Laurie Leader - Re: Building Permit Application 201501700 - Reviewer?

For the Maine Muslim Community Center at 118 Anderson Street we received comments both from you and from Jenn Bartlett in the Fire Marshall's office.

▪ [A1.1 - Plans & Code Review.pdf](#)

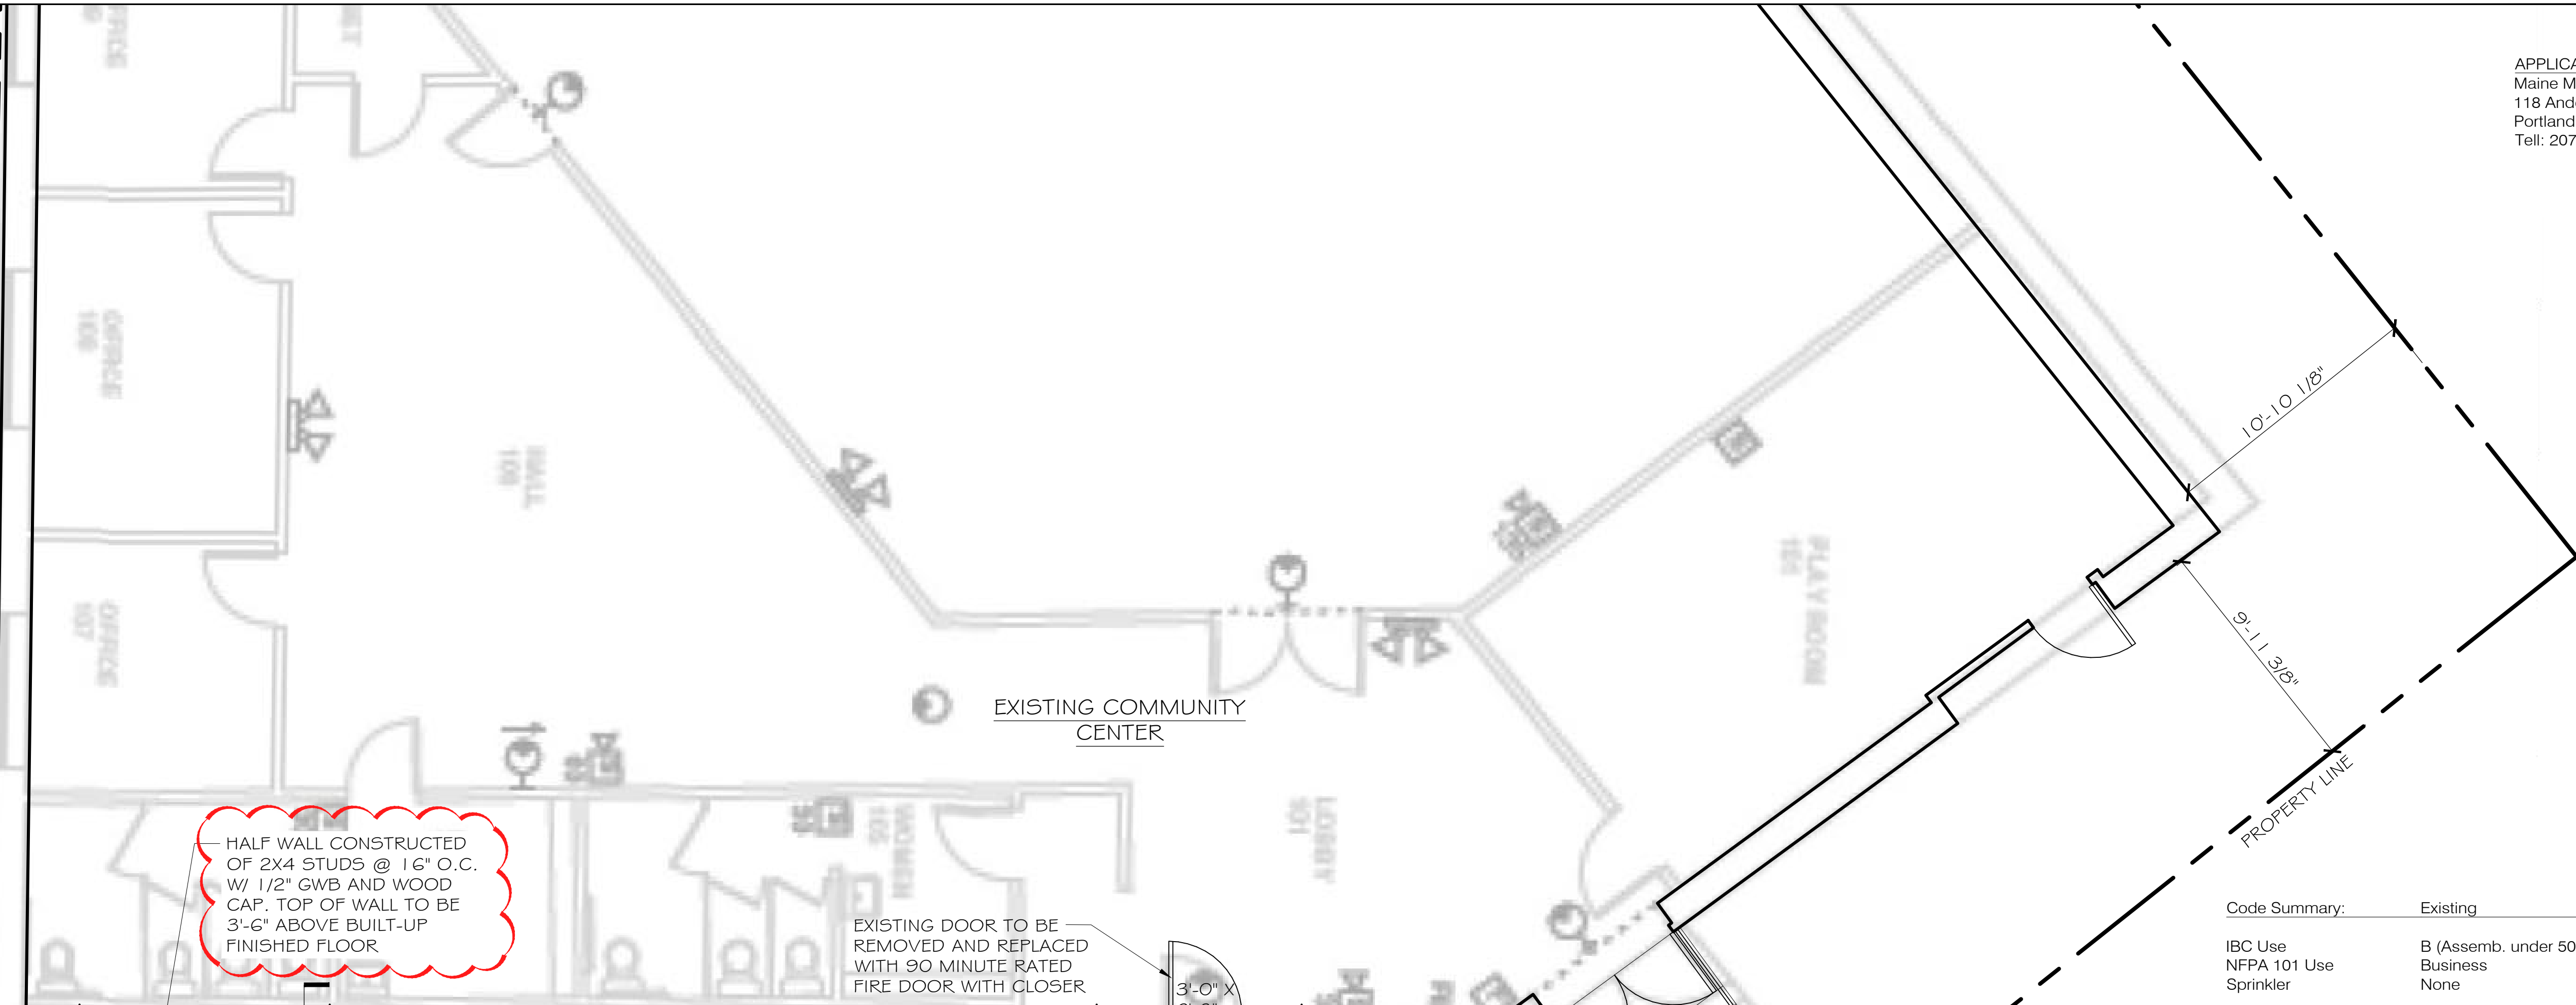
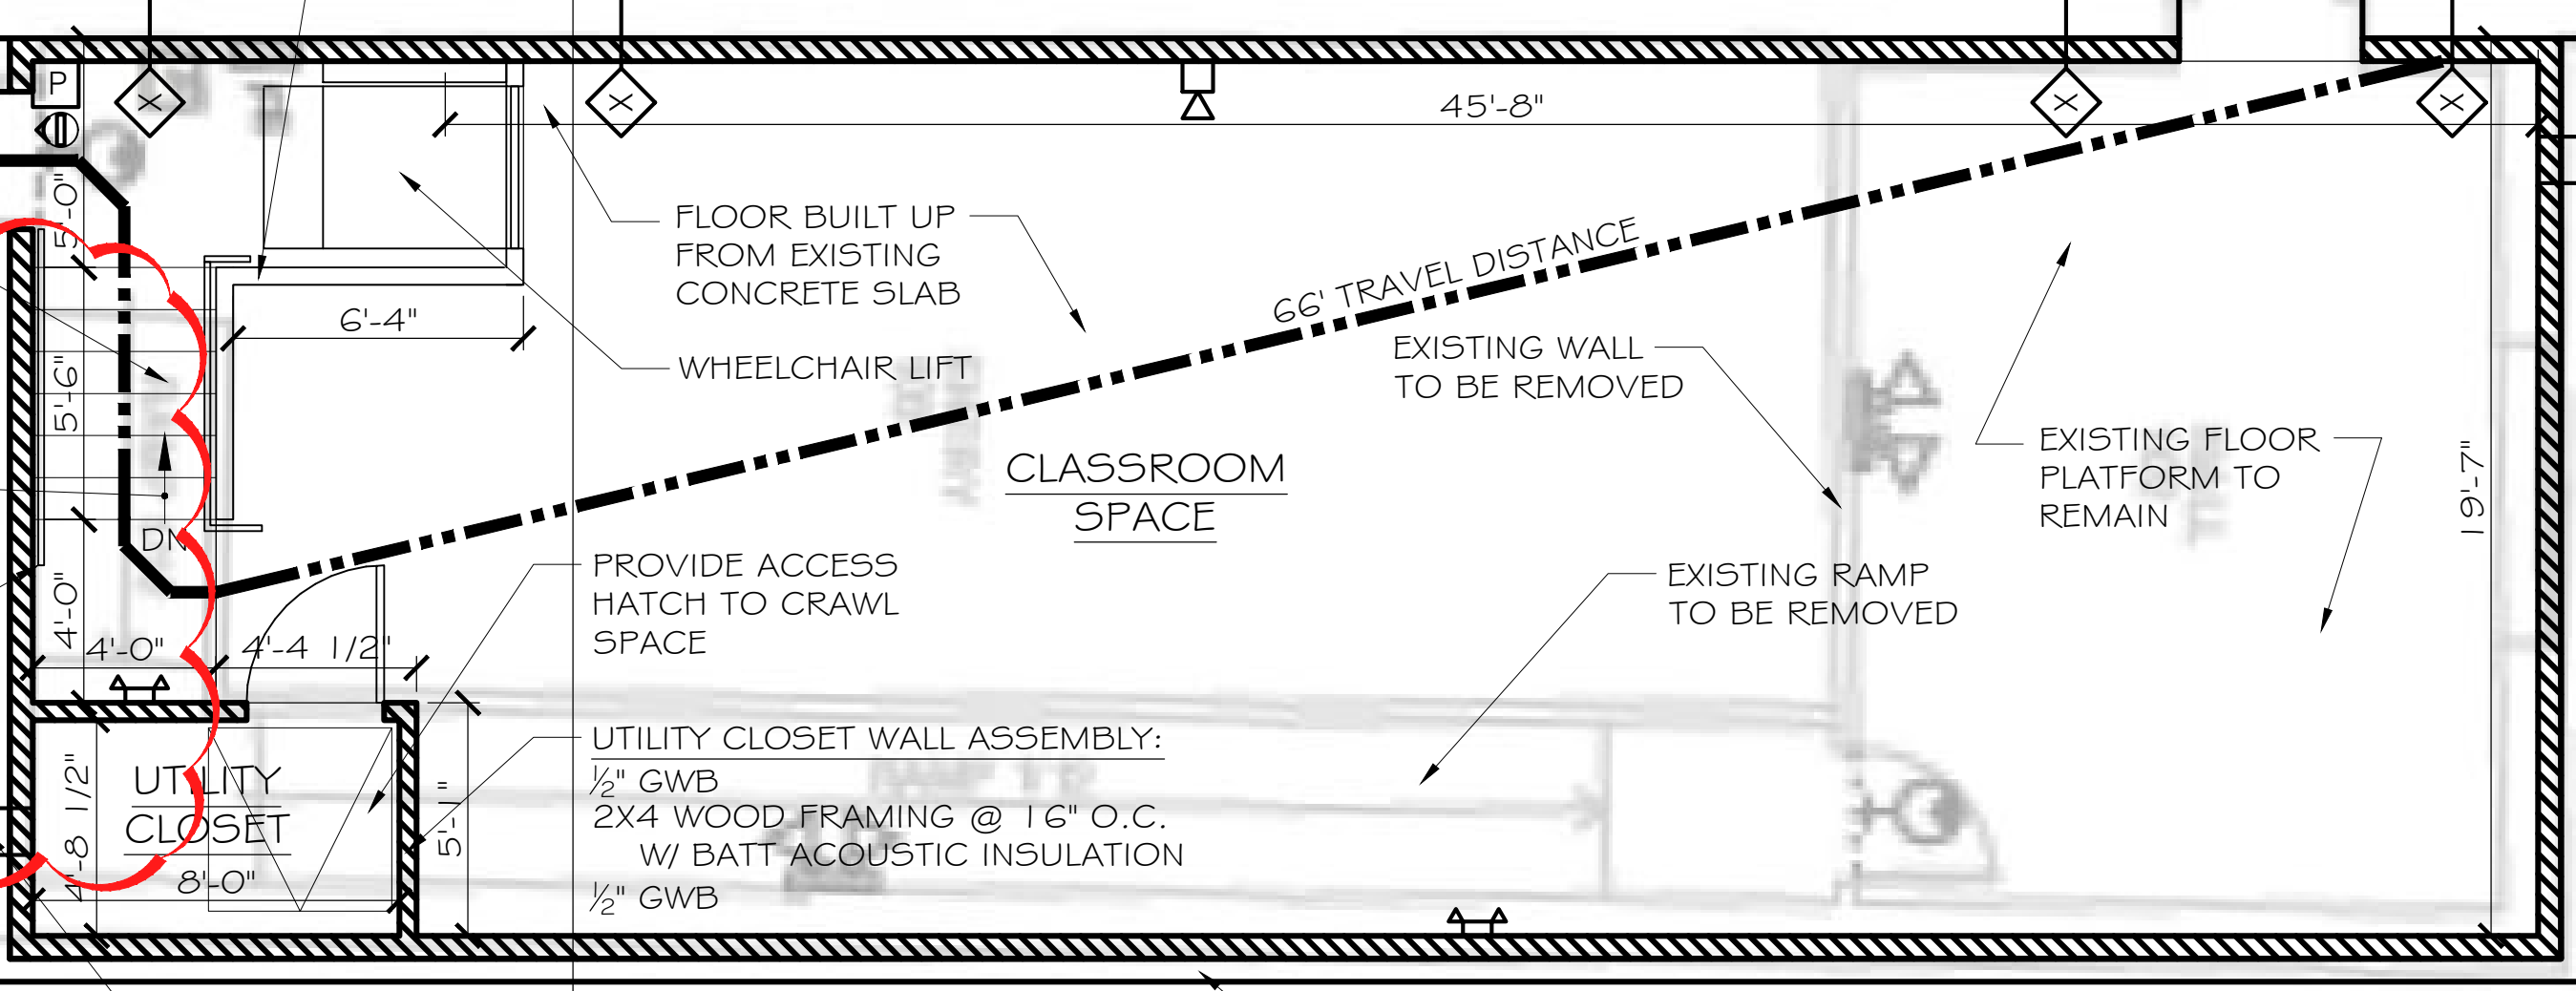
This resulted in the decision to go with a wheelchair lift instead of a ramp. This lift is on the interior of the building, and is serving the building from the same location as the previously existing ramp.

We have also noted the inclusion of ventilation under the floor, as well as a seating plan that allows circulation to the stair and ramp.

▪ [A1.2 - Section and Details.pdf](#)

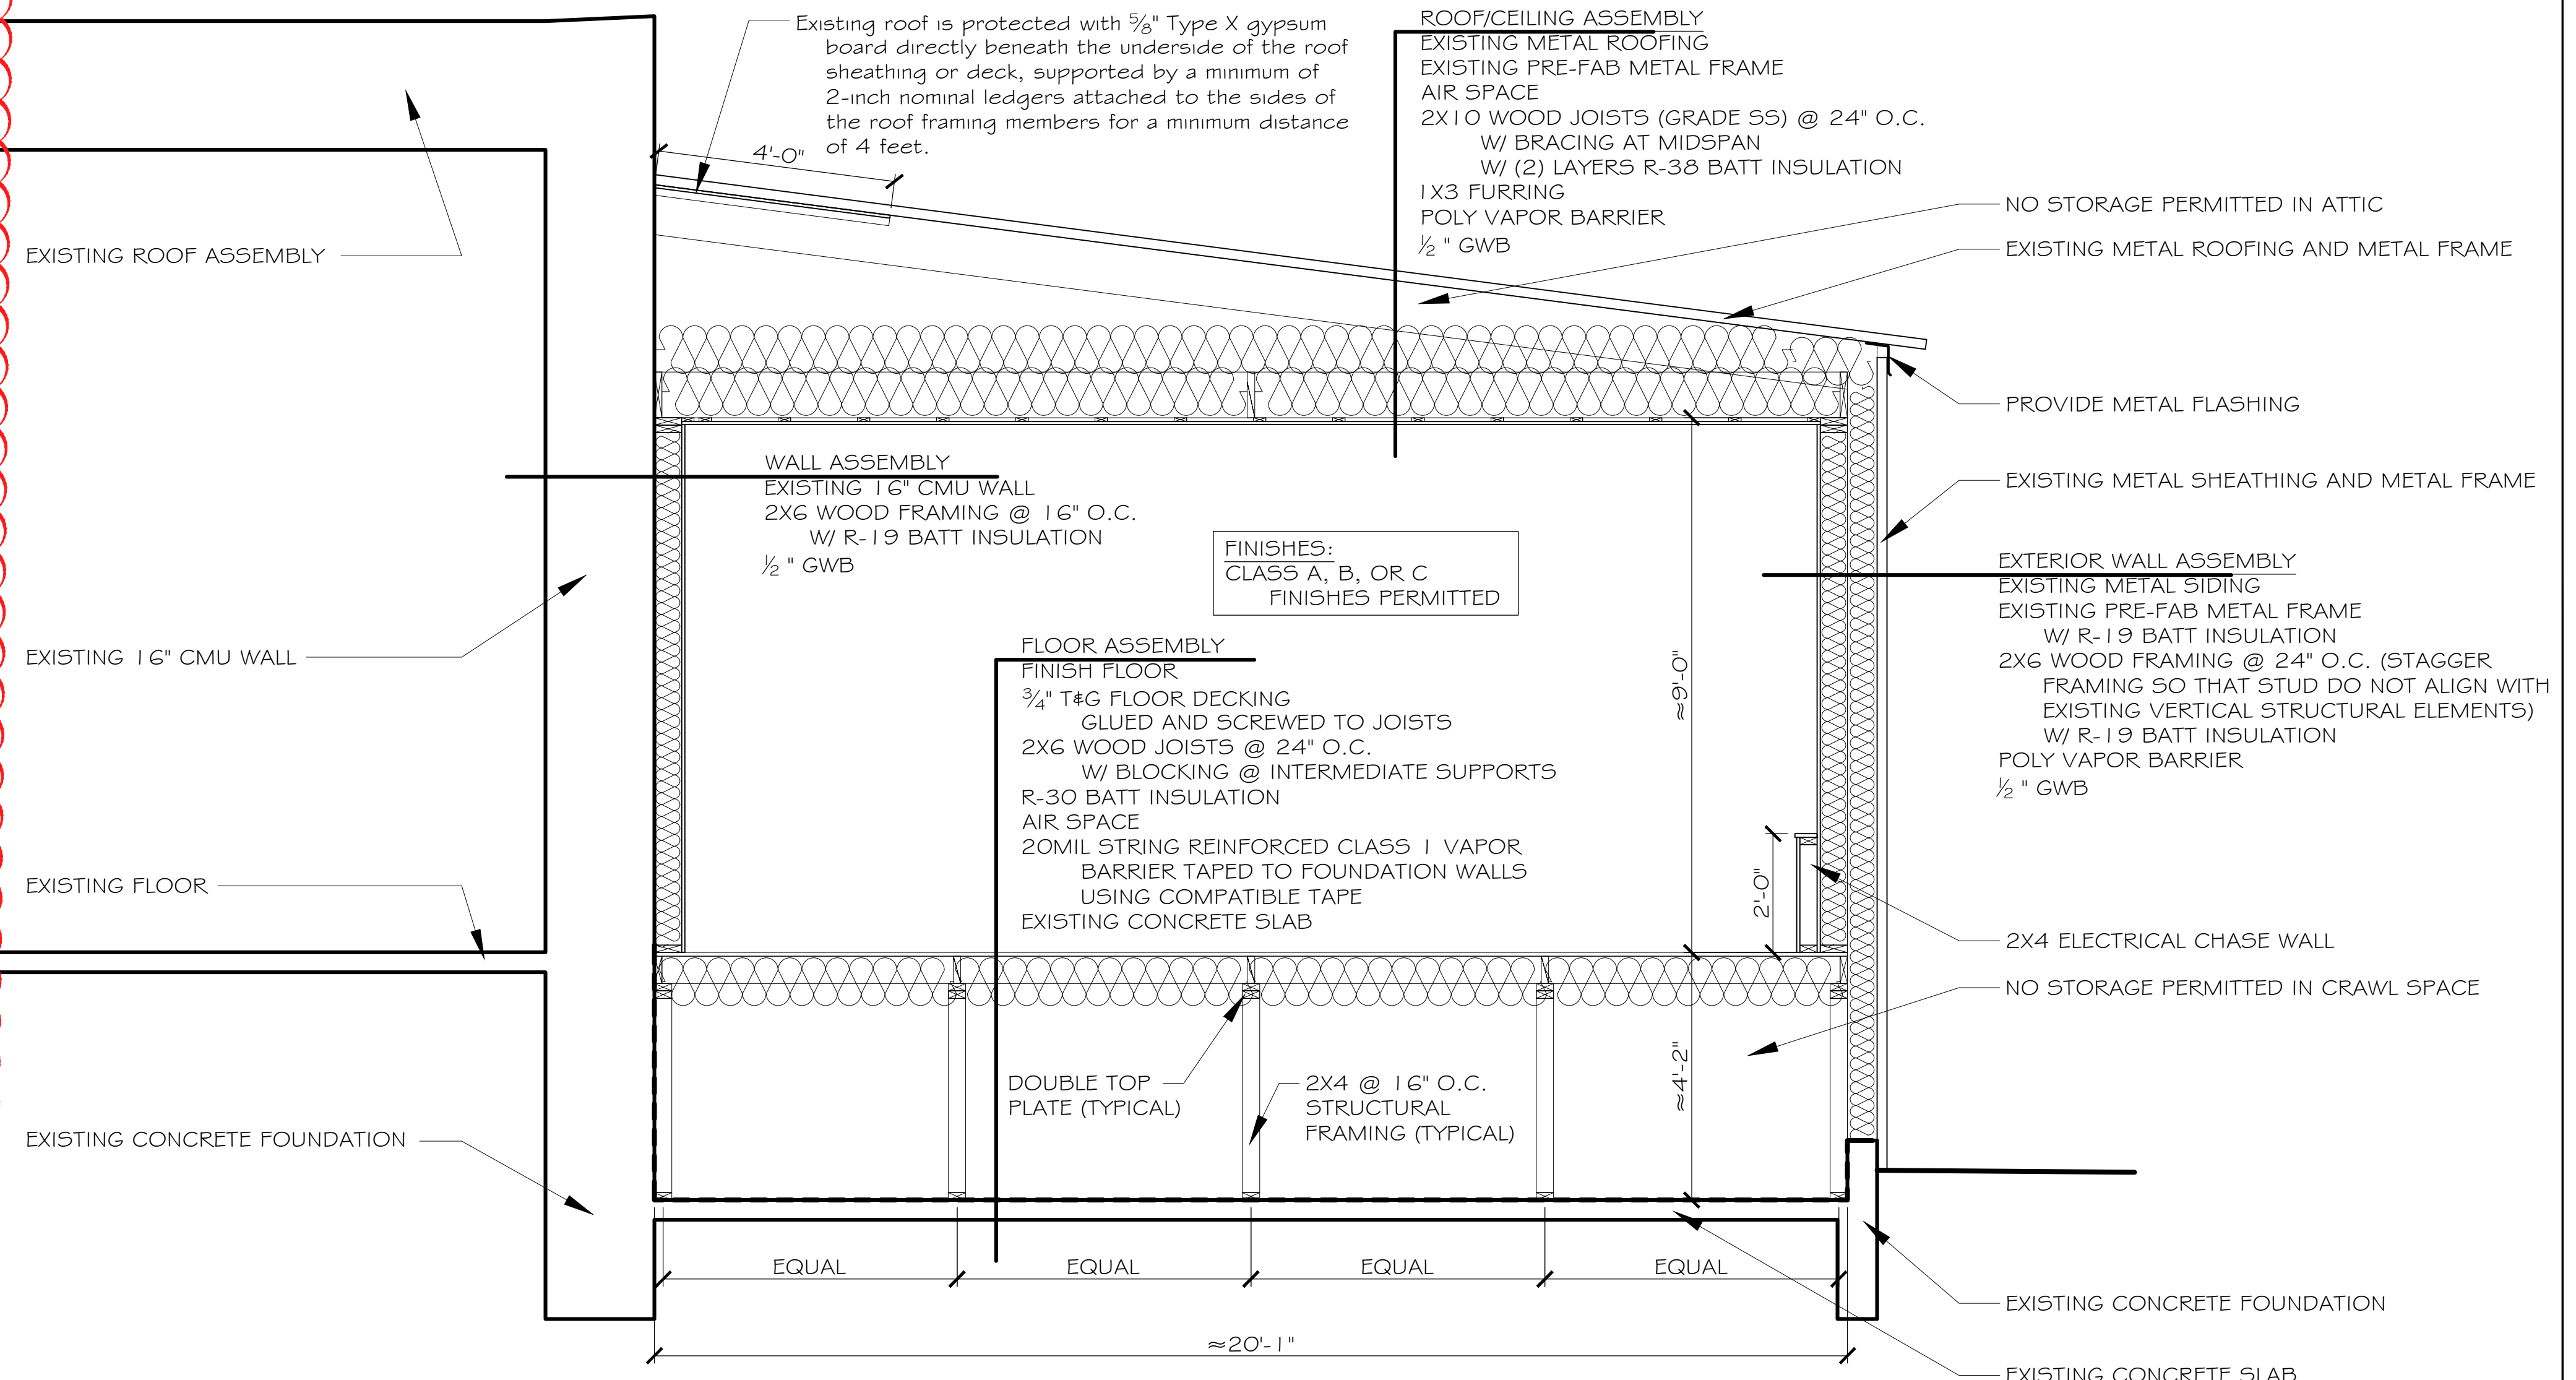
Lastly, we've added a note that the ages of people using the space will be mixed and that it is not intended to be used for children only.
